April 14, 2022

Re: Caterpillar Clubhouse
803 2nd St. SW
Traffic Circulation Layout
Architect's Stamp 04-01-22 (K14-D227)

Based upon the information provided in your submittal received 04-04-22, the above referenced plan cannot be approved for Building Permit until the following comments are addressed:

A3 ENLARGED RAMP DETAIL
SCALE: 1" = 8'-0"

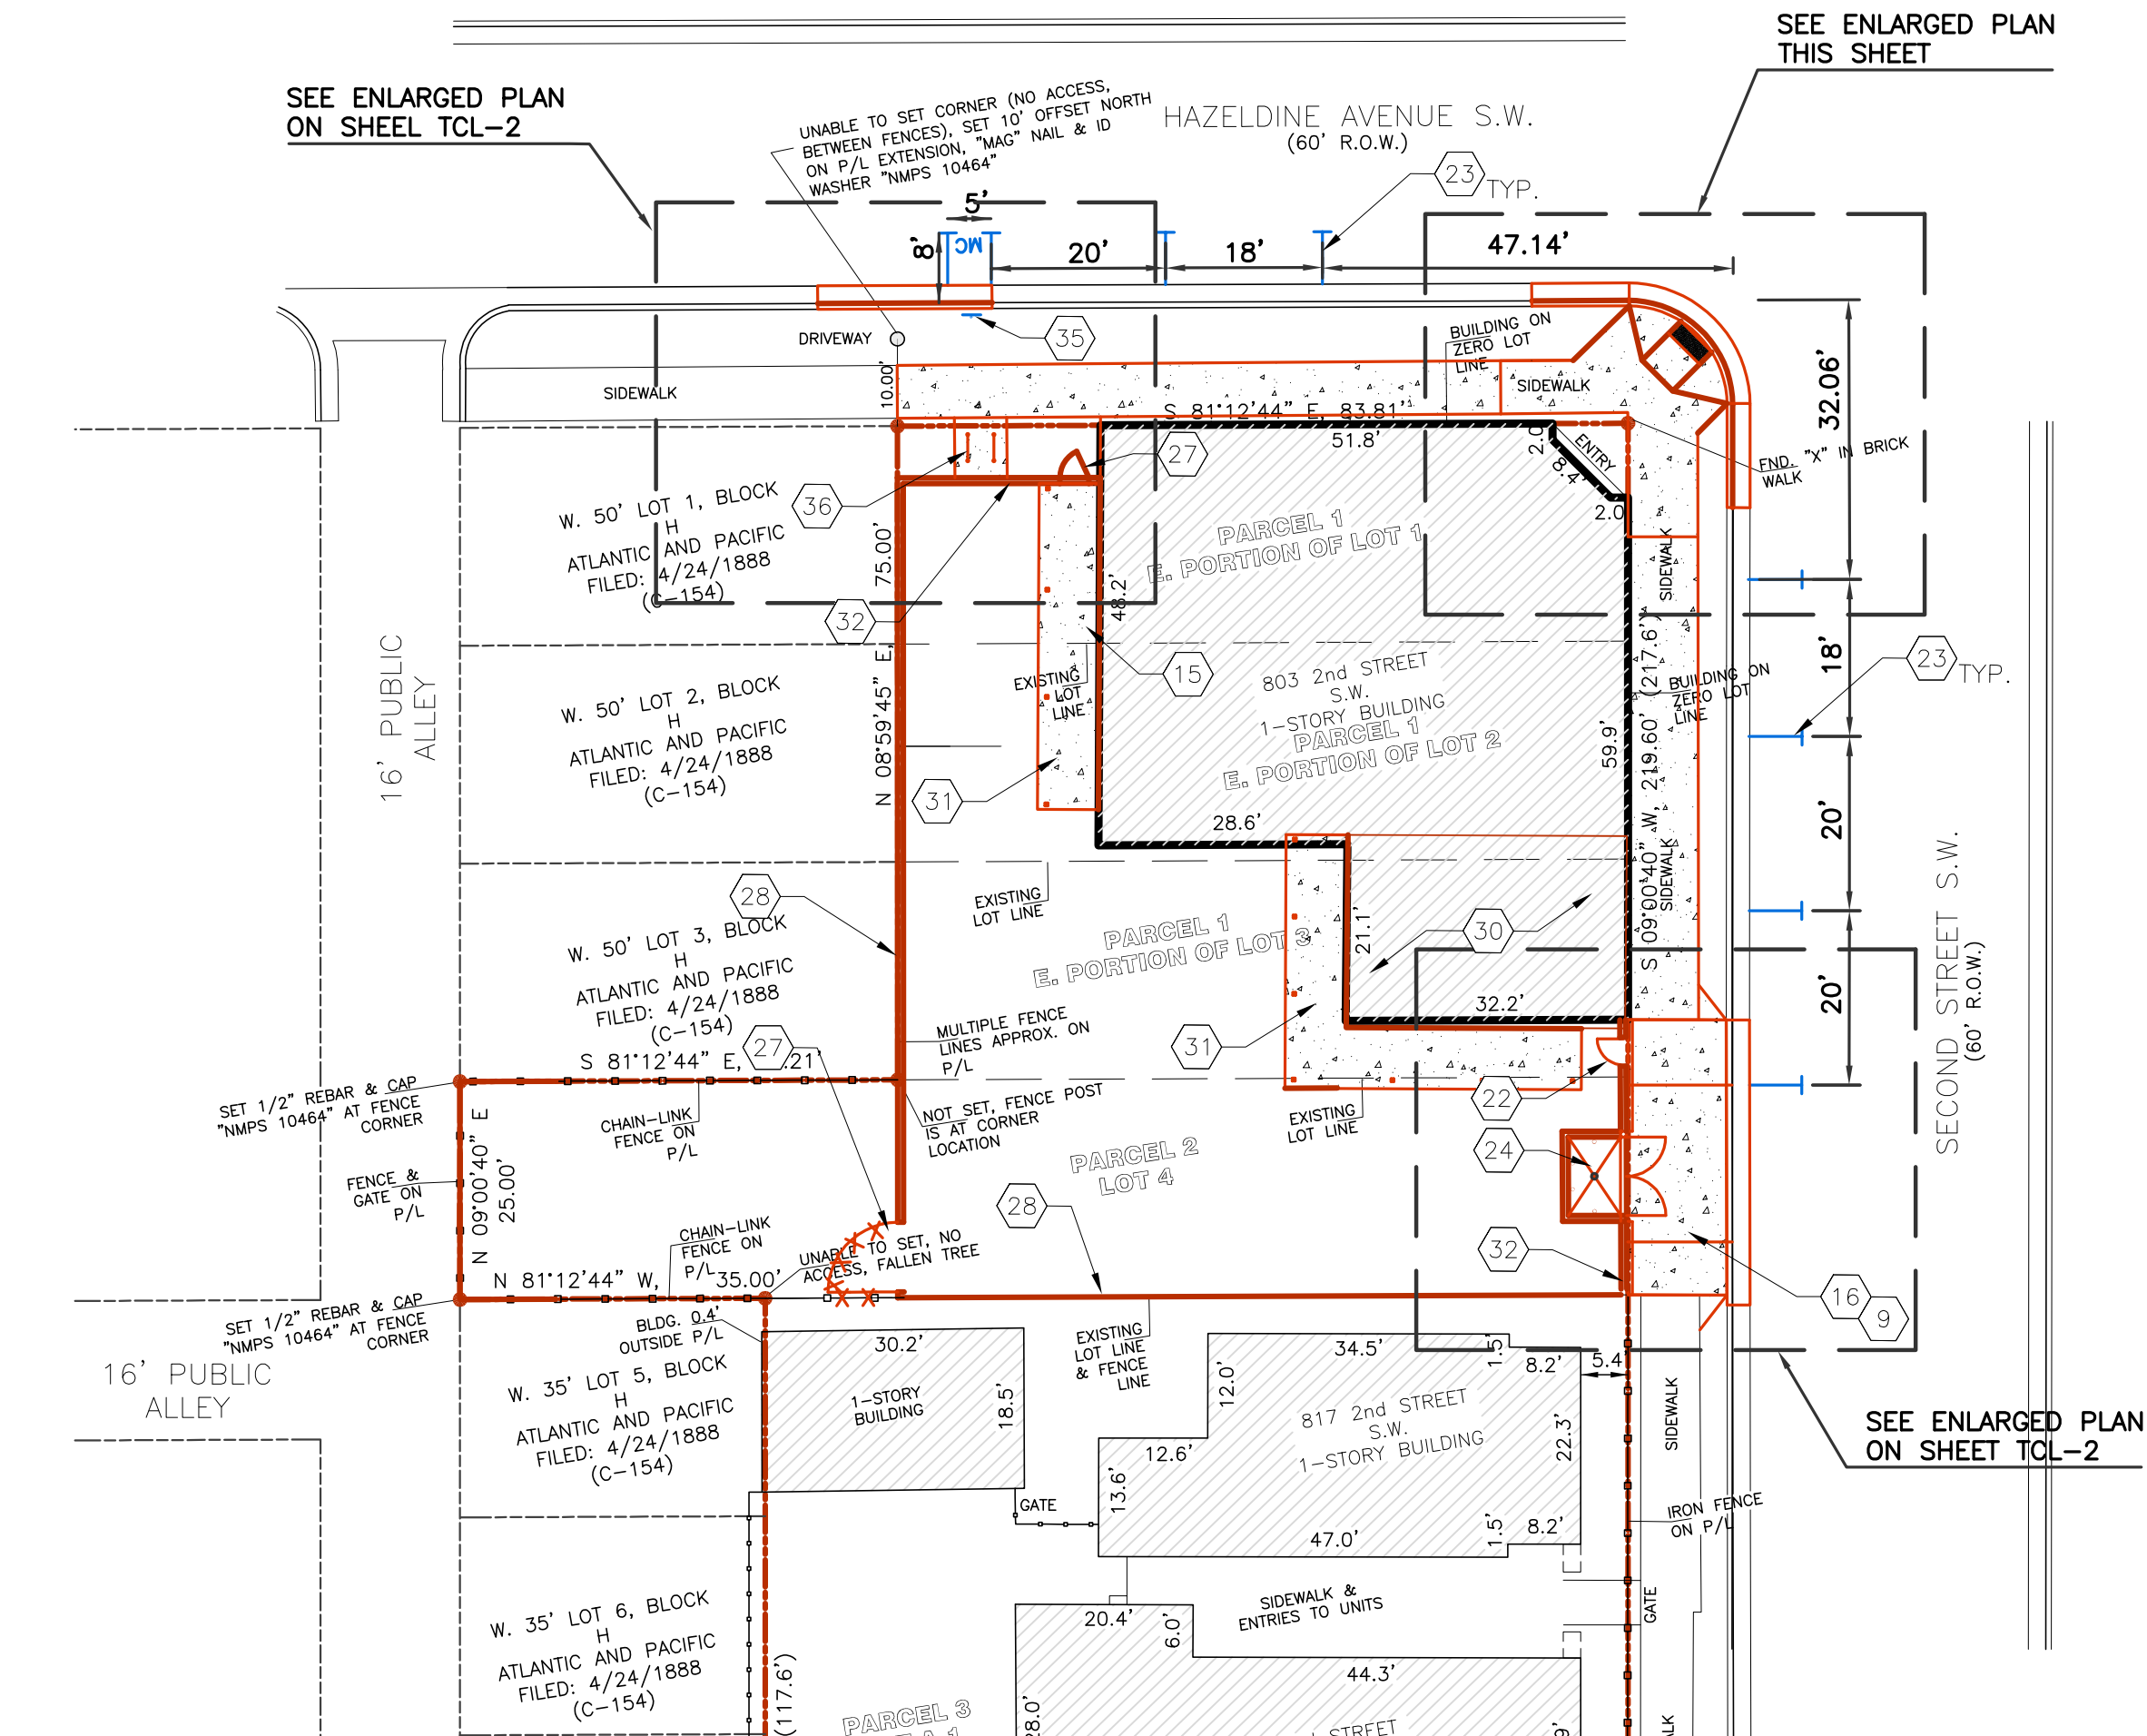
3. ADA parking stall is not permitted on Public Right of Way Per City Engineer.
4. Handrail is not permitted on Public Right of Way Per City Engineer.
5. Call out COA std dwg for the Driveway off 2nd st.

A1 TRAFFIC CIRCULATION LAYOUT
SCALE: 1" = 20'-0"

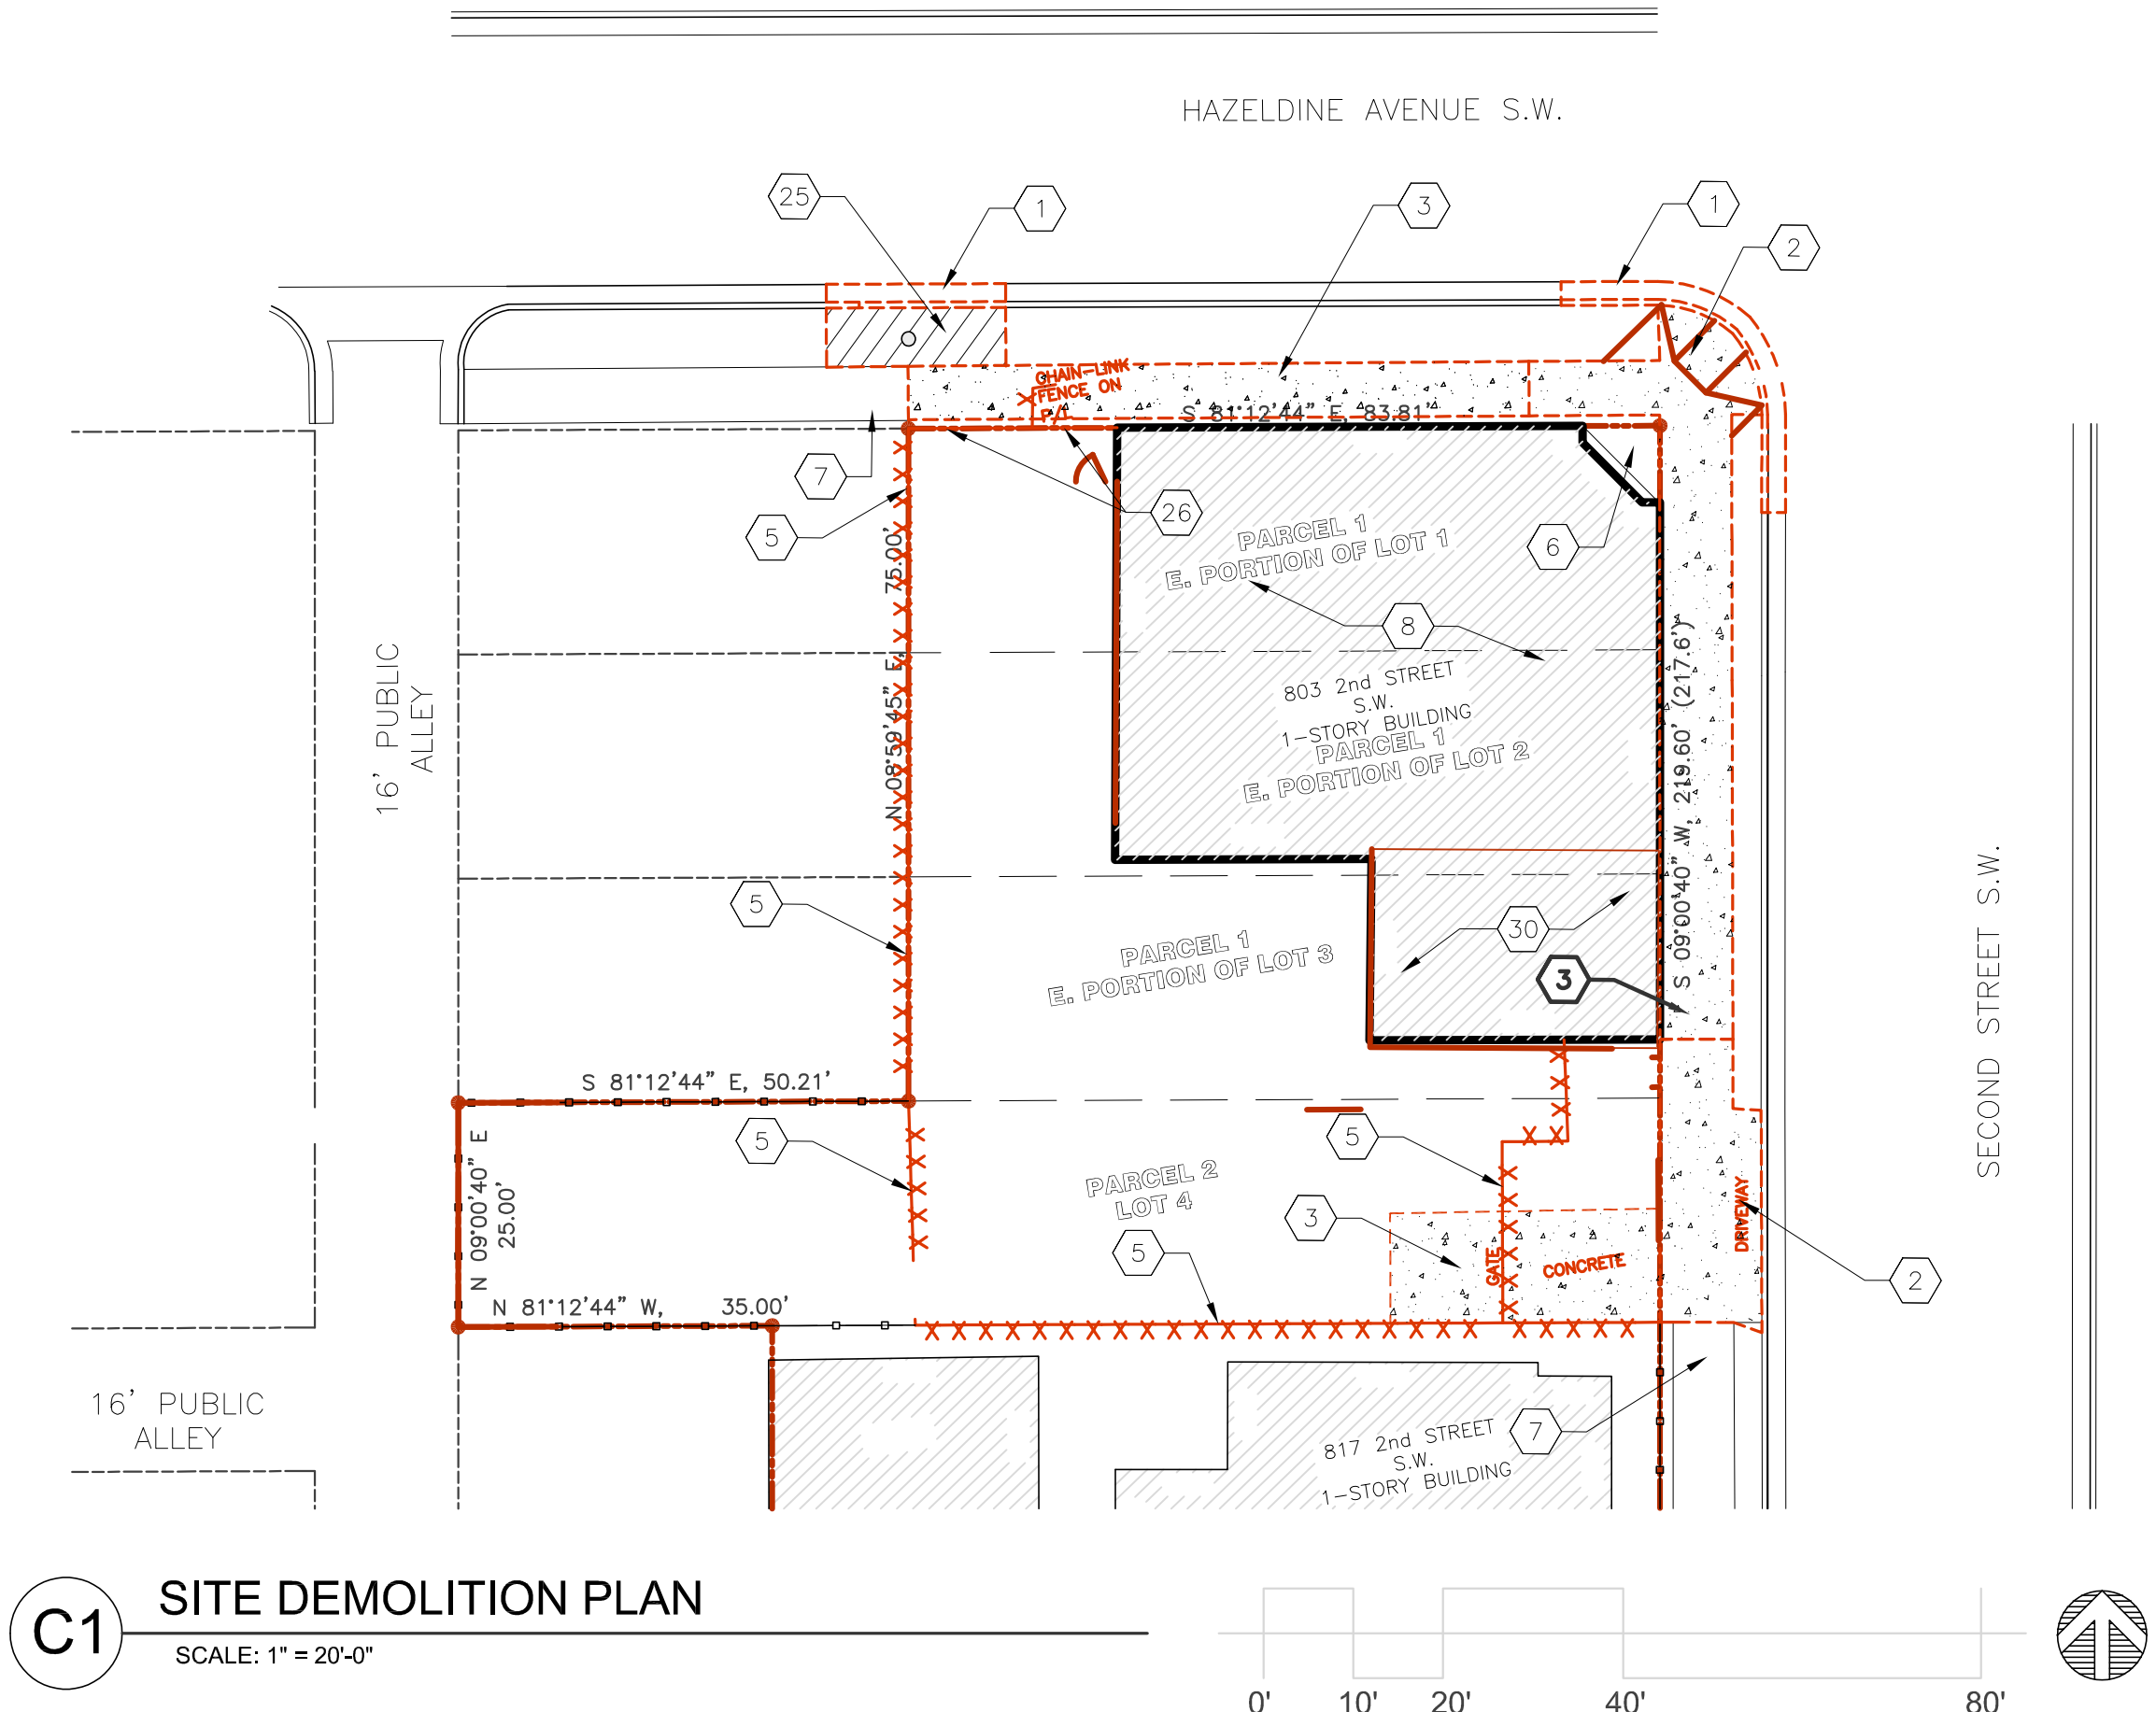
6. Provide the dimension from the on street parking stall to the intersection of 2nd st. and Hazeldine Ave. show this dimension on site plan.
7. On-street parking spaces need to be 20' long.

8. Show the intersection sight distance for the driveway entrance off 2nd St. and add the following note to the plan: "Landscaping and signage will not interfere with clear sight requirements. Therefore, signs, walls, trees, and shrubbery between 3 and 8 feet tall (as measured from the gutter pan) will not be acceptable in the clear sight triangle

9. Show the clear sight triangle for the driveway entrance off Hazeldine Ave. and add the following note to the plan: "Landscaping and signage will not interfere with clear sight requirements. Therefore, signs, walls, trees, and shrubbery between 3 and 8 feet tall (as measured from the gutter pan) will not be acceptable in the clear sight triangle
